EL PASO COUNTY

Office of the County Attorney
Civil Division

MS-21-2 Bradley Point Filing No. 1

WATER SUPPLY REVIEW AND RECOMMENDATIONS

FINAL PLAT  
BRADLEY POINT FILING NO. 1  
JOB NO. 70-074  
DATE PREPARED: 01/29/2021  
DATE REVISED: 08/22/2023

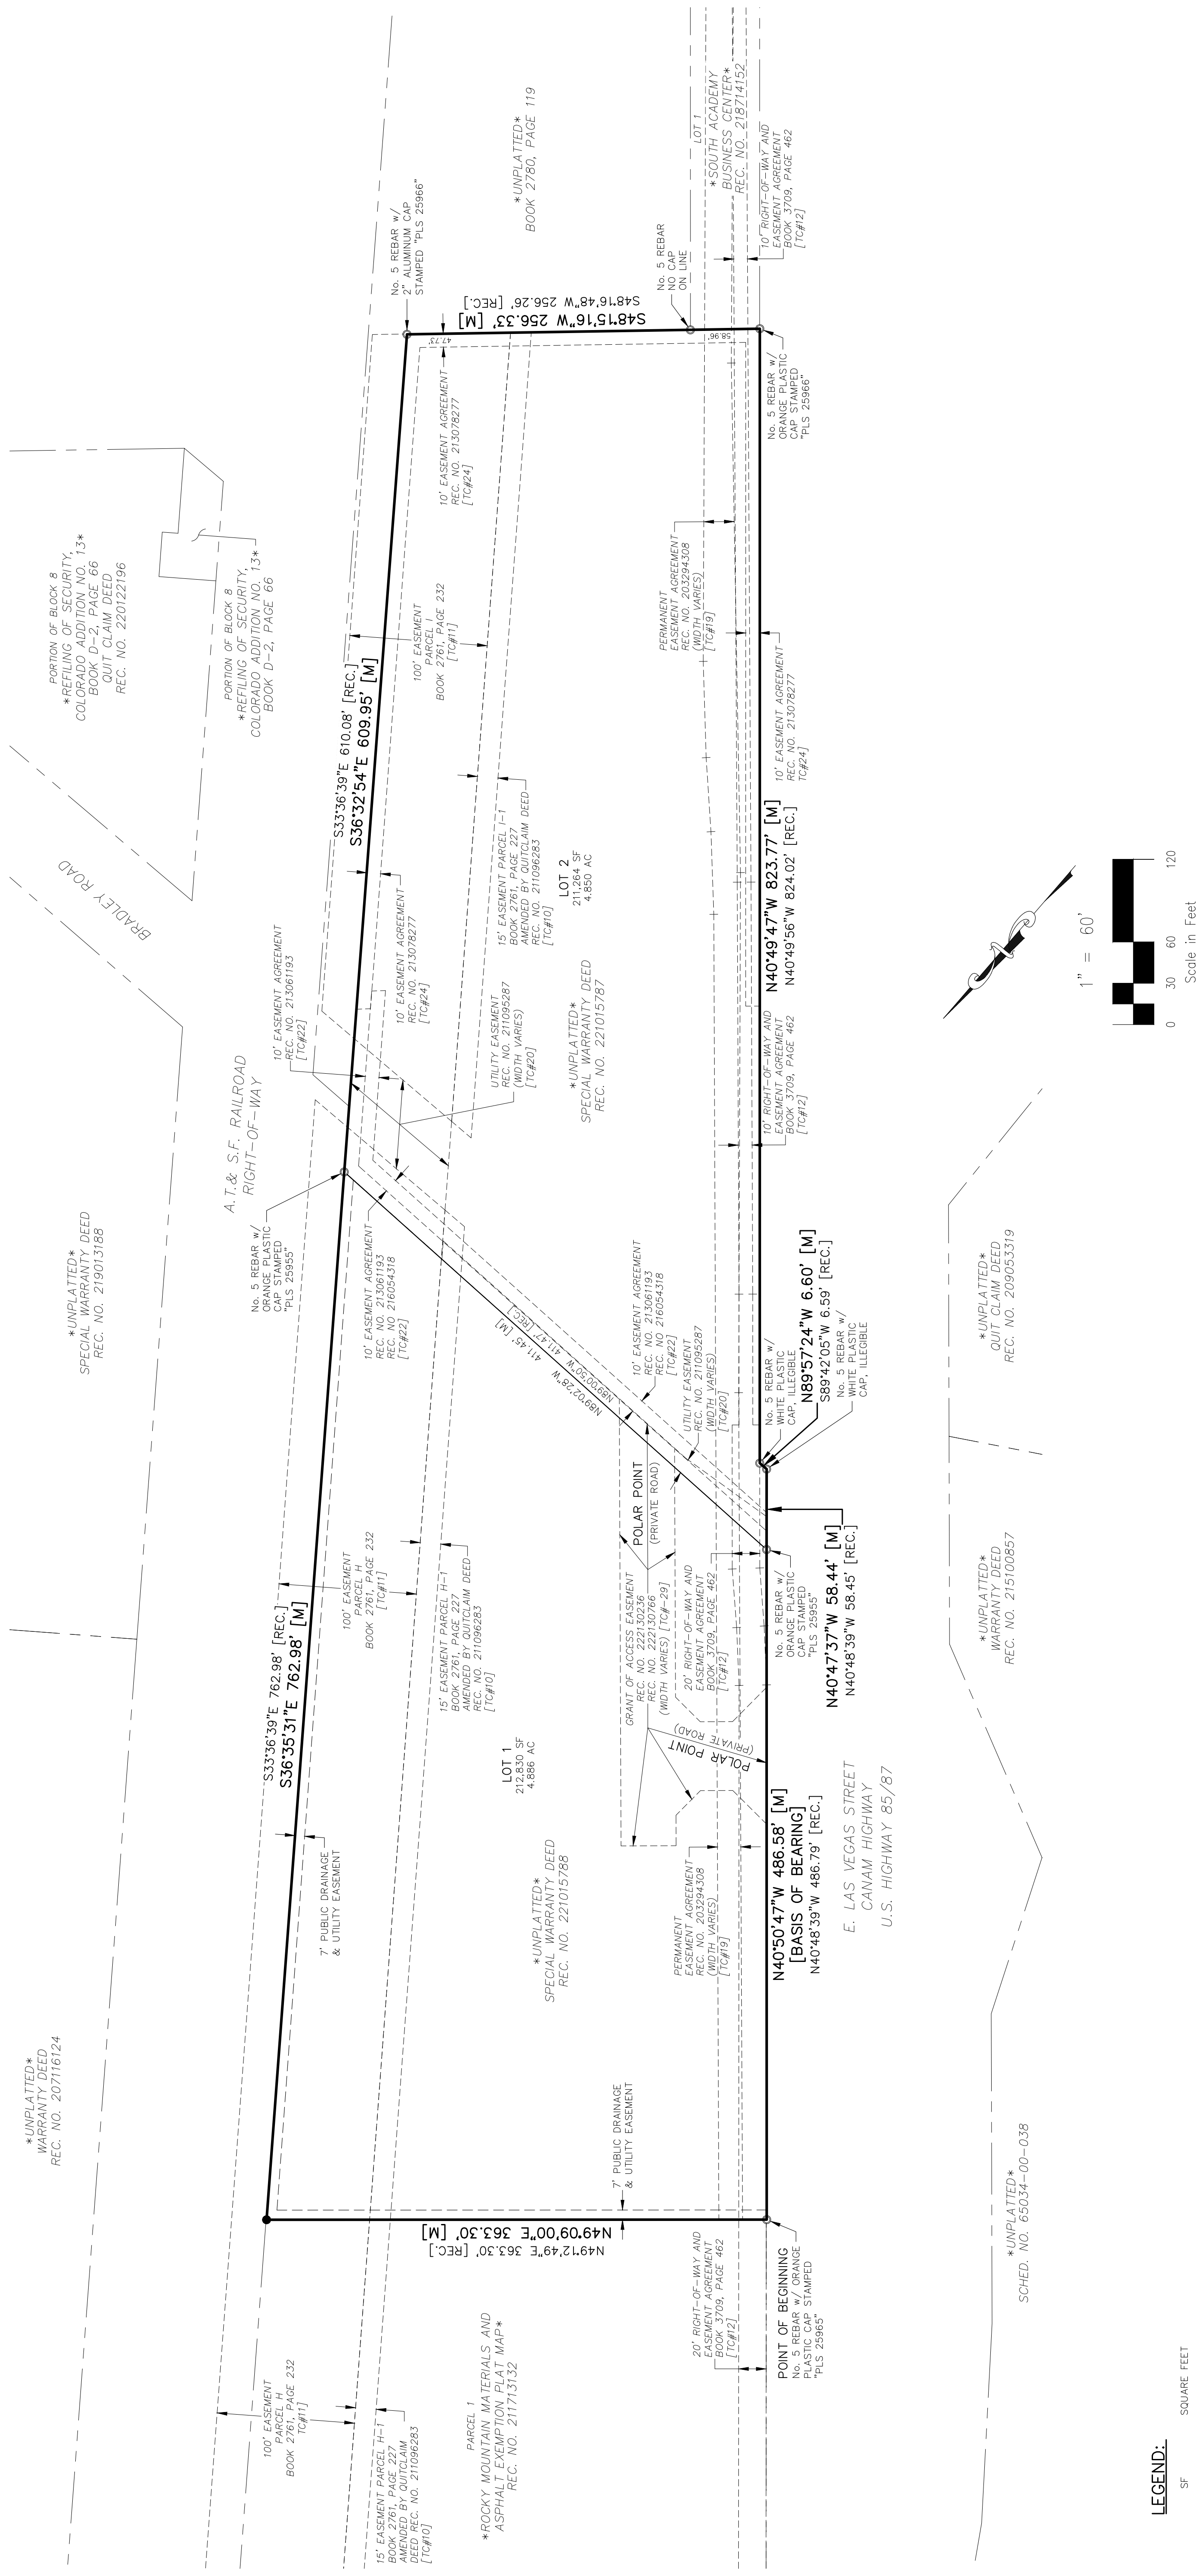
- A. Applicant and all future owners of lots within this filing shall be advised of, and comply with, the conditions, rules, regulations, limitations, and specifications set by the District.
- B. **Prior to recording the final plat:**
 - 1. Delete Note 10 from the face of the plat.
 - 2. Provide for review by the County Attorney's Office an updated letter of intent that removes all references to this being a dry subdivision and that addresses the water sufficiency criteria for final plats, as a typical letter of intent would.
